SUBMISSIONS REPORT

SSDA-8865 Mod 1
St Anthony of Padua Catholic
College

Prepared for
SYDNEY CATHOLIC SCHOOLS
3 August 2021

Drawing
CAR + BICYCLE PARKING PLAN

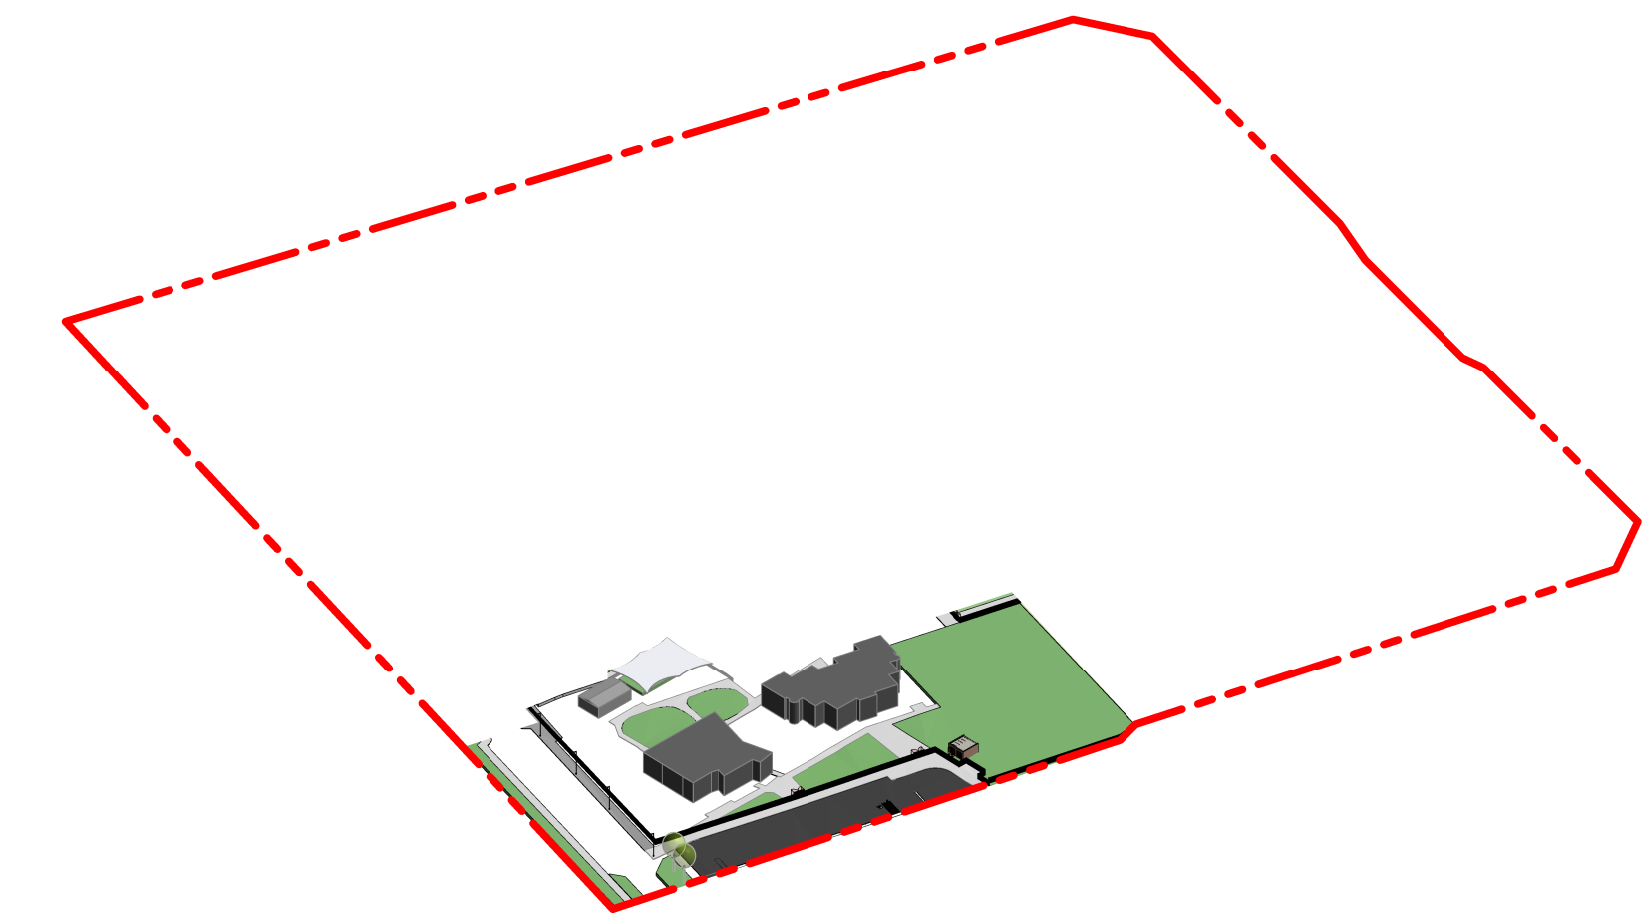
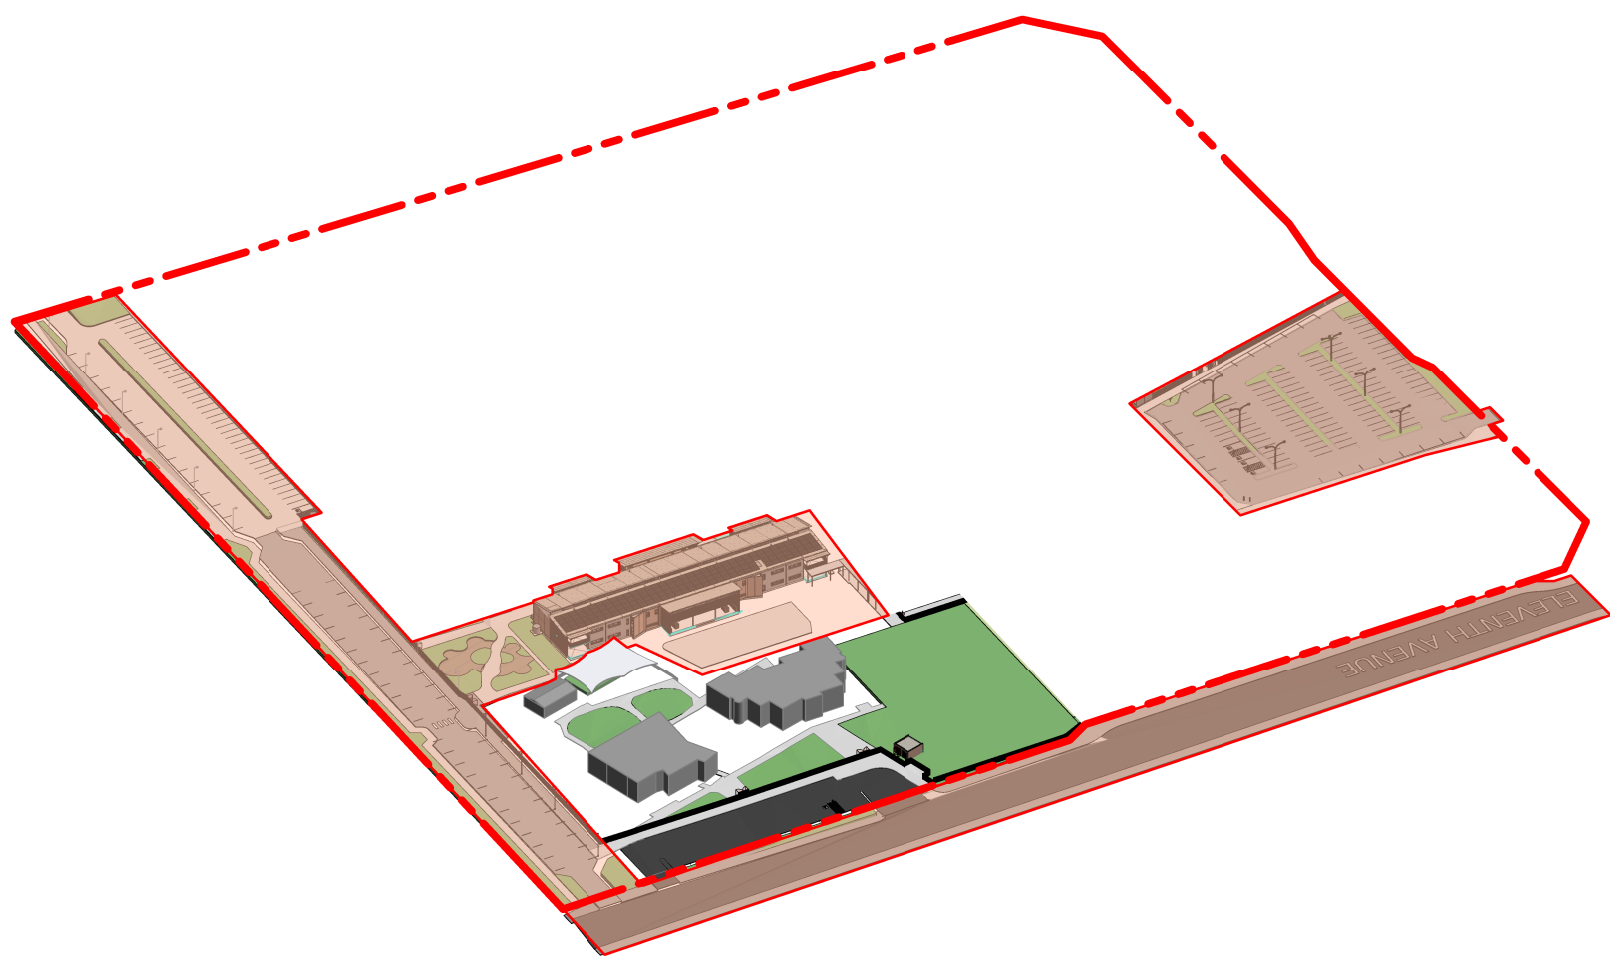
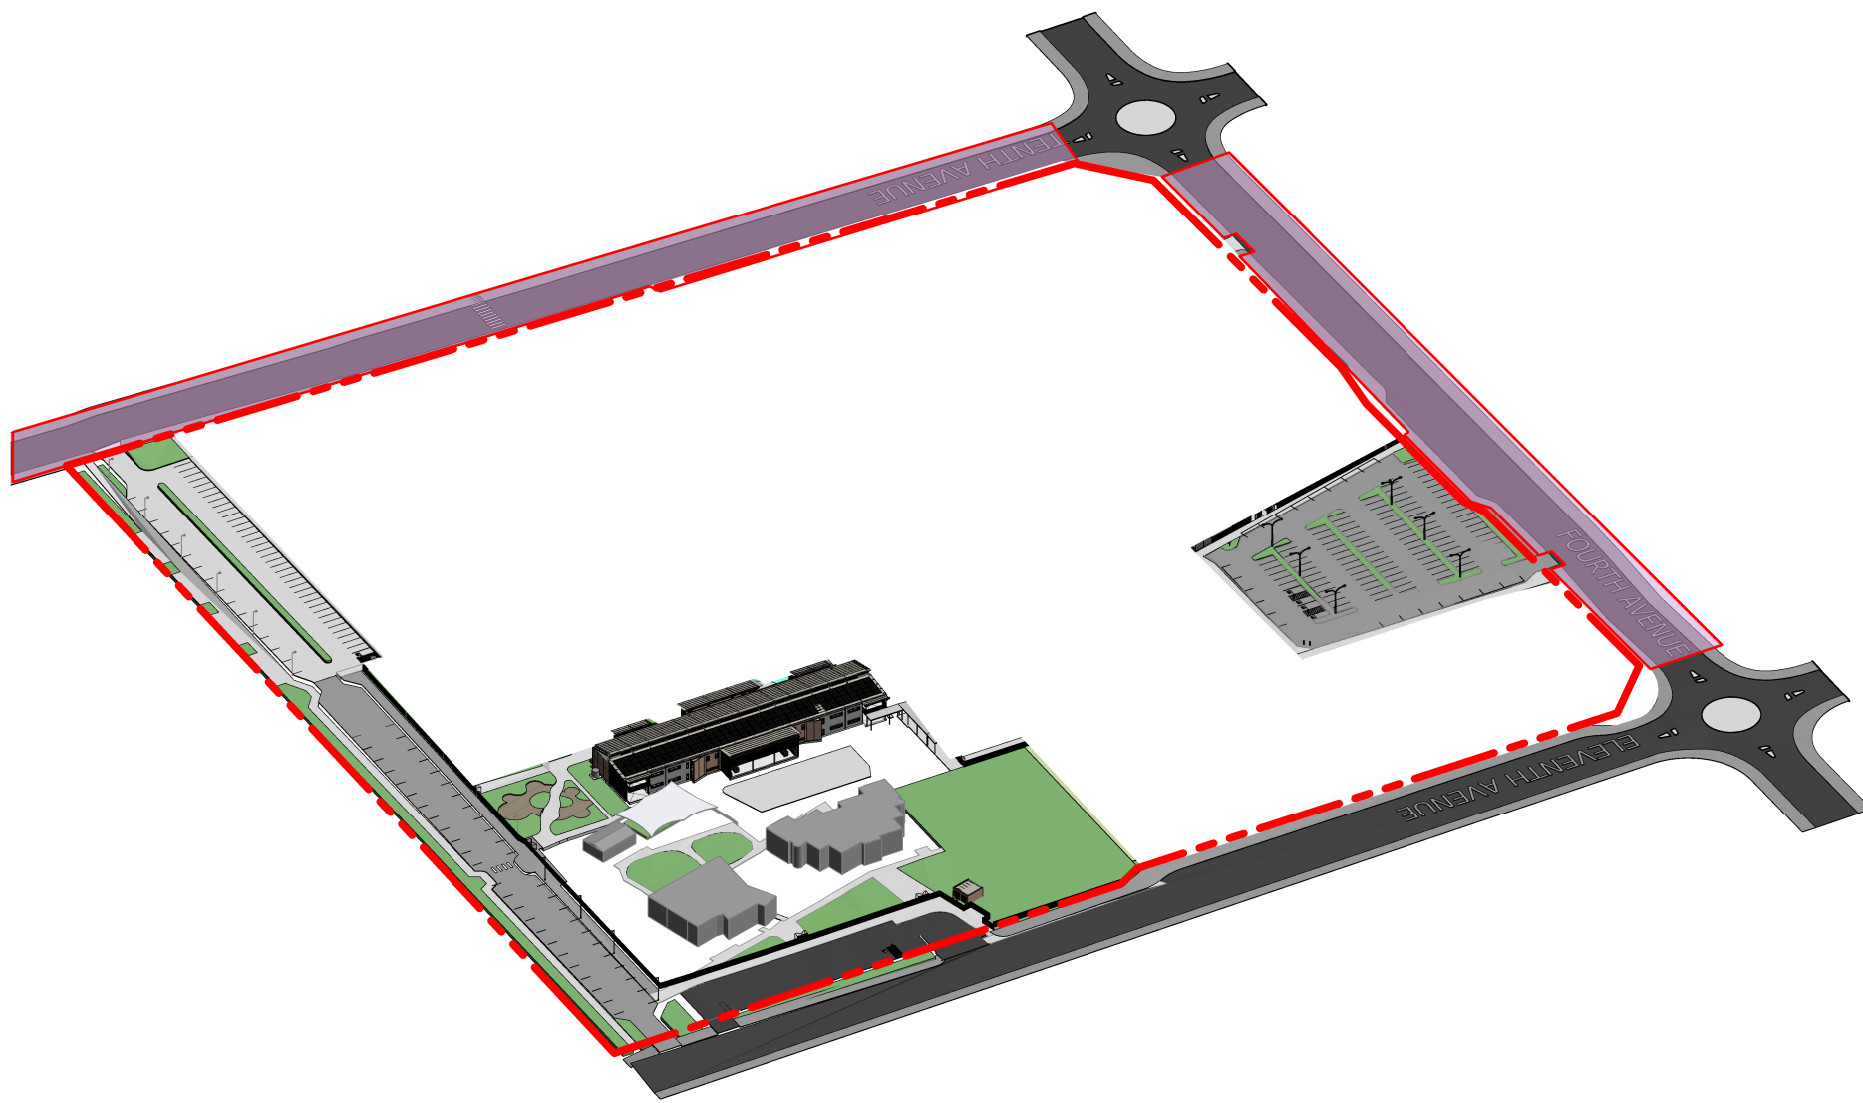
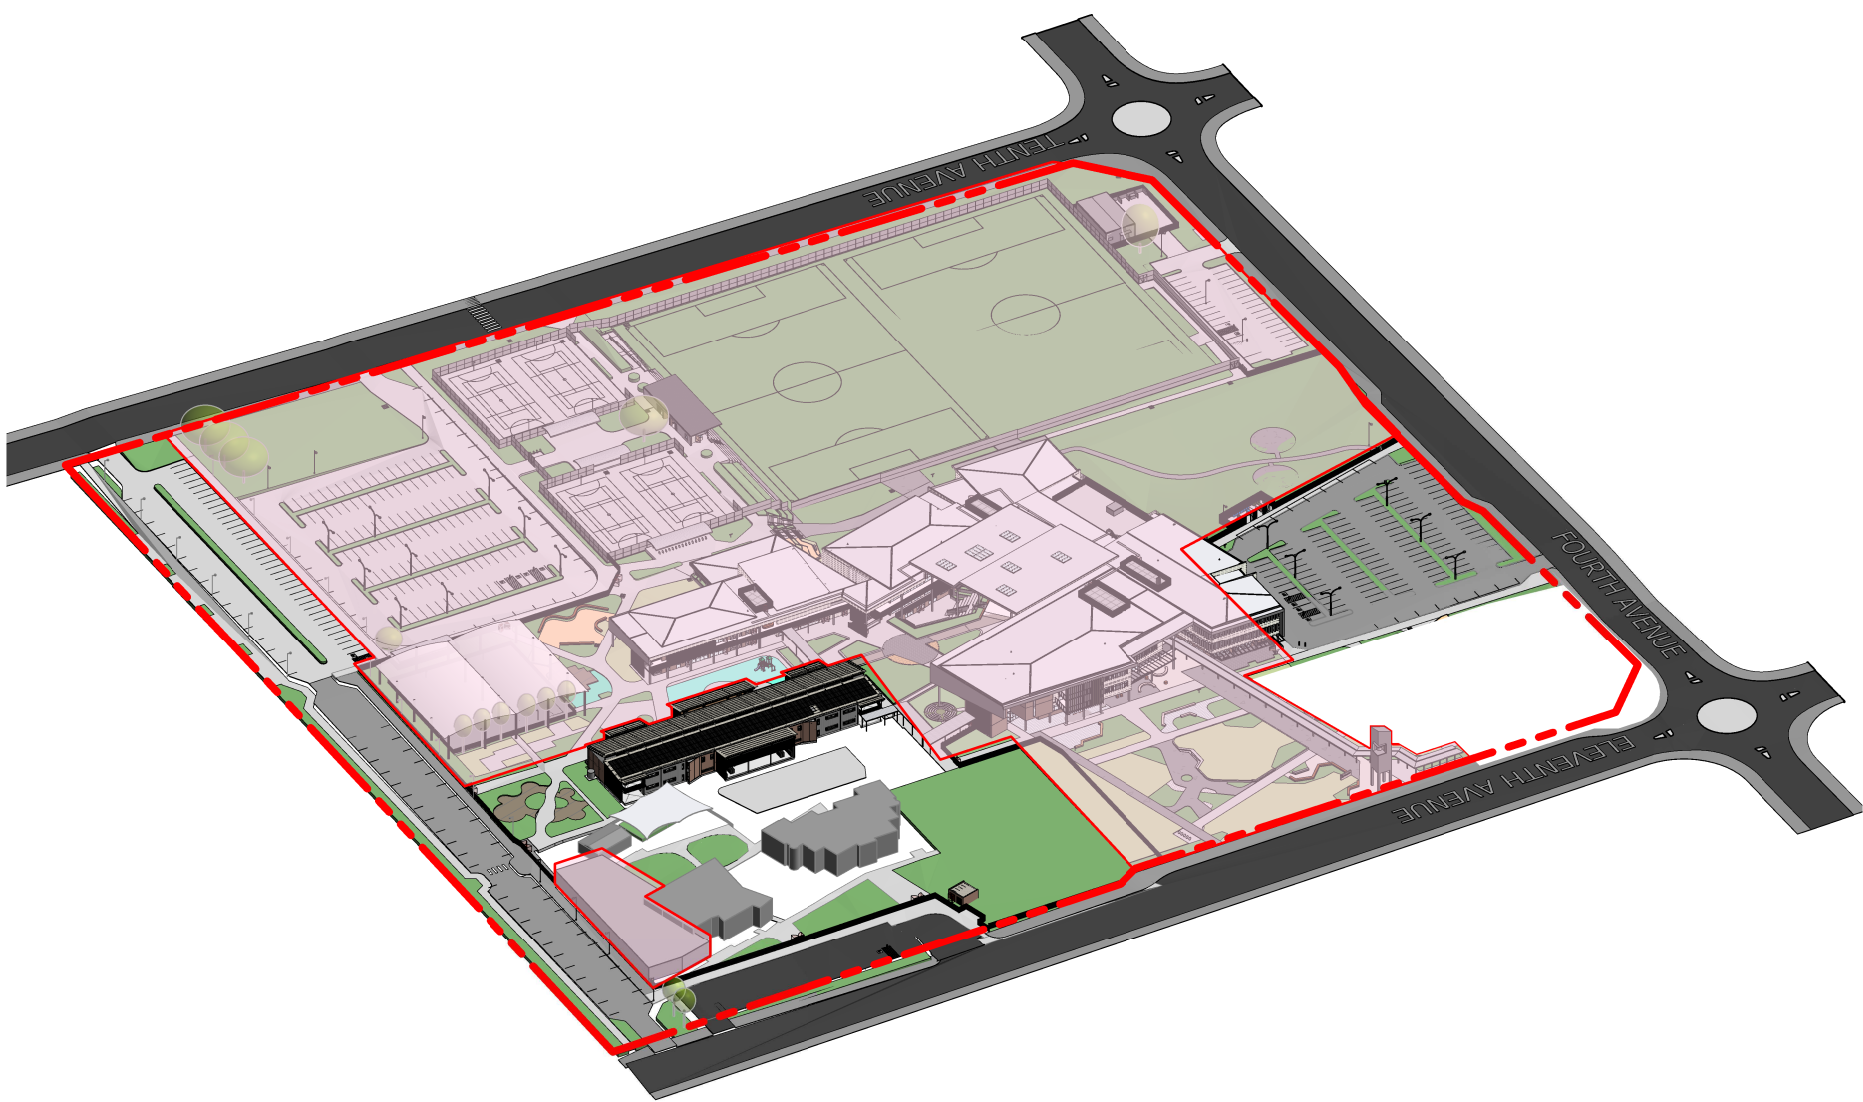
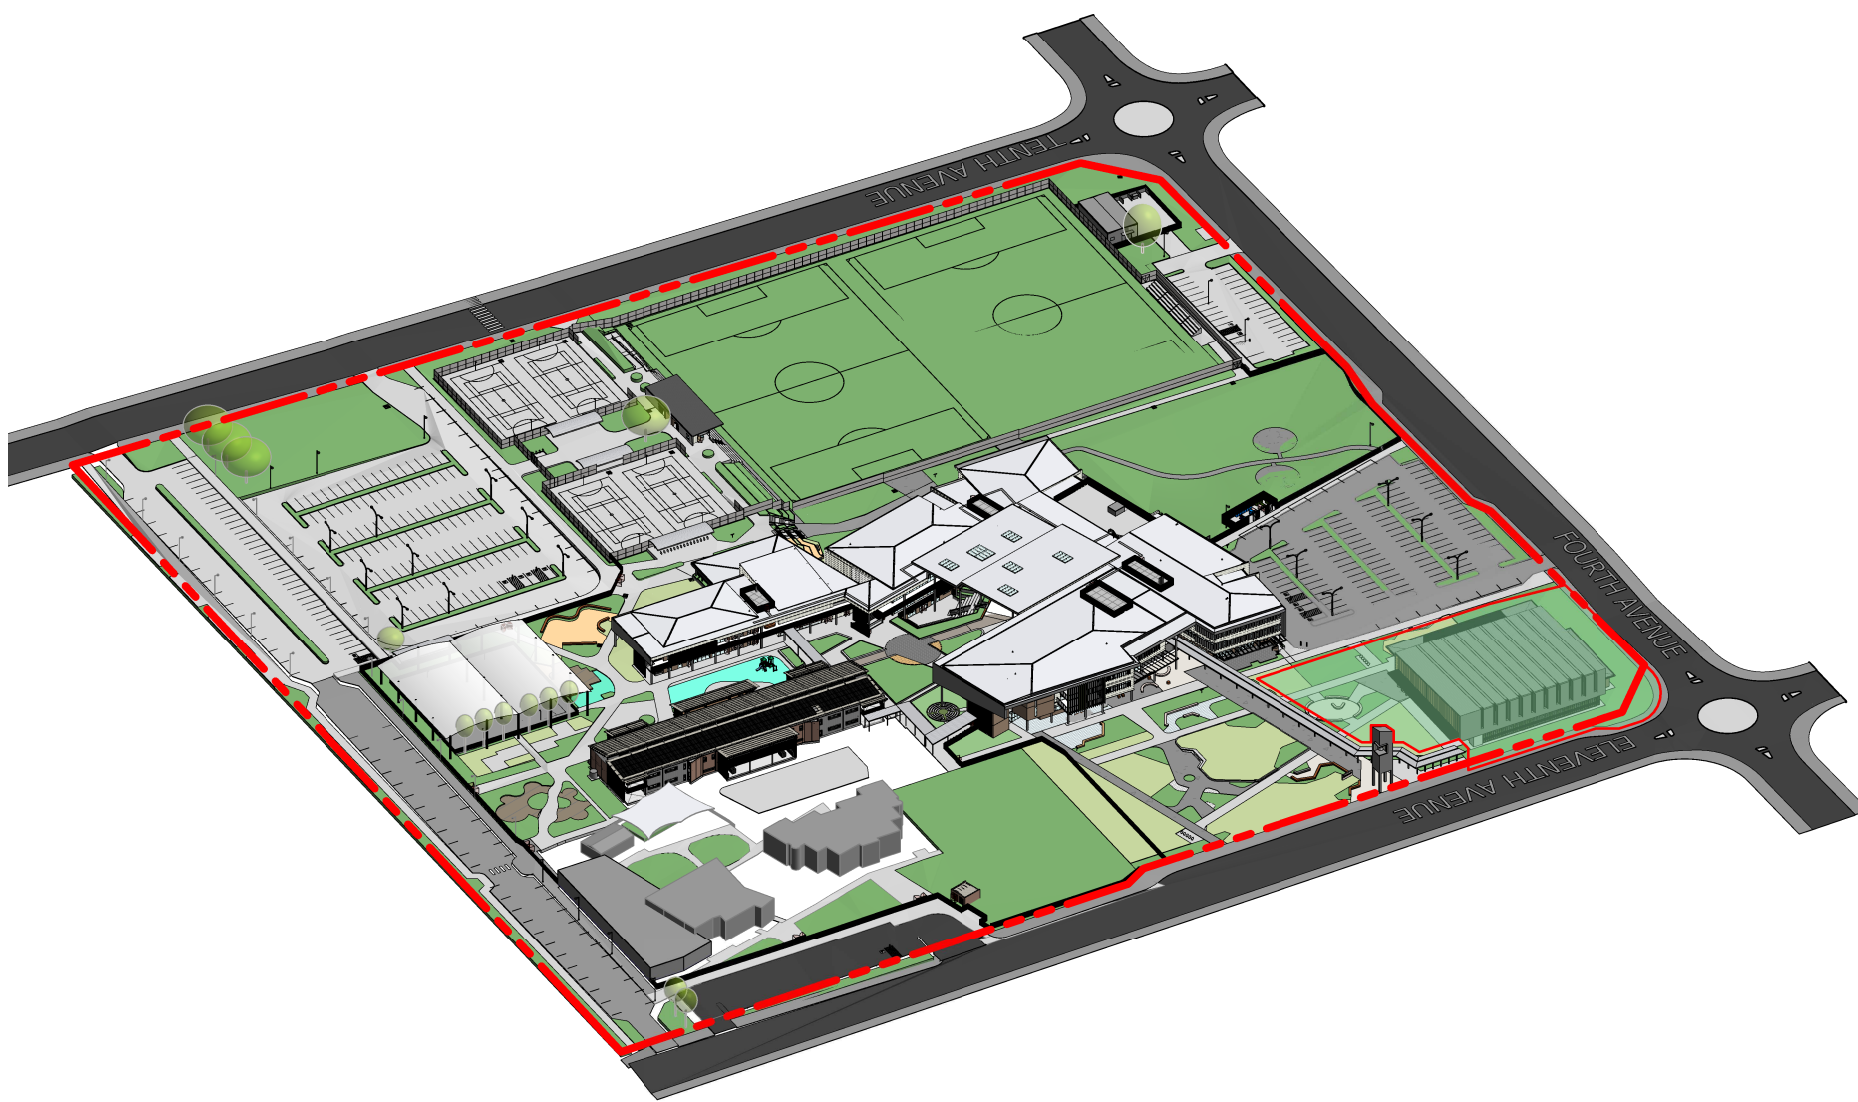
Issue	Referral comment	Response to submission
4.	- why the approved 'Phase 1' and proposed 'Existing' figures differ, as indicated in proposed Condition B8 Table 1. For example, the 'Existing' figures show a reduction in both car and bicycle parking spaces when compared to the previously approved 'Phase 1'.	The carparking and bicycle parking numbers approved as Phase 1 were intended to reflect the existing parking and bicycle provision on the site and should have been identified as 'existing' rather than 'Phase 1'. Since the SSDA approval and the engagement of a new project architect the proposed carparking layouts have been refined. While the approved total number of car parking and bicycling spaces has not changed, they have been distributed slightly differently across the site. With the reduction in the number of phases, the majority of carparking will be delivered in Stage 1. Stage 1 is under construction and the site currently provides 66 car parking spaces, 42 drop off spaces and 10 bicycle spaces.
